ARBORICULTURIST'S COMMENTS.

From: Ian Brewster
Sent: 21 May 2013 16:17
To: Janice Chapman
Subject: AW/97/13/T Land Adj to 9 Acorn End Aldwick PO21 4JA

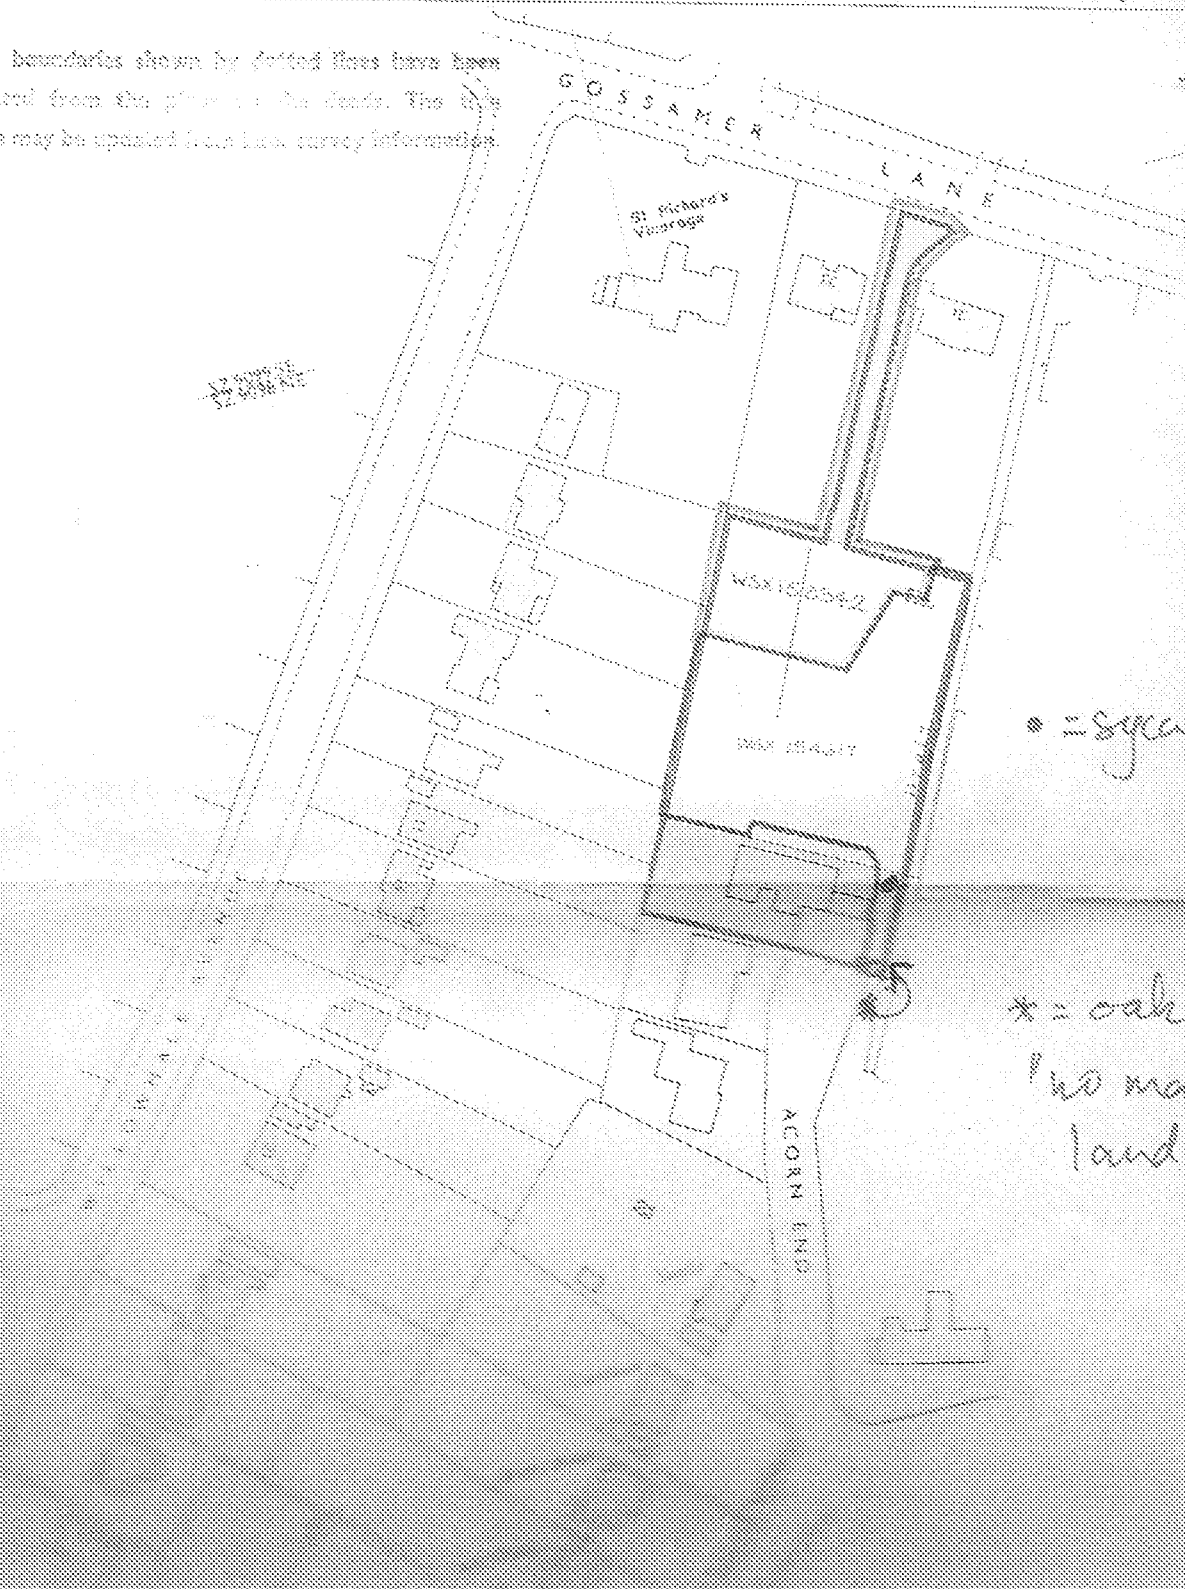
I have no objection to make with regard to the proposed tree work.

As a suggested condition; The reduction should be restricted to the areas nearest the property but wound sizes should determine branch lengths to be removed where they should not exceed 50mm in diameter. I hope this is acceptable to the tree owner.
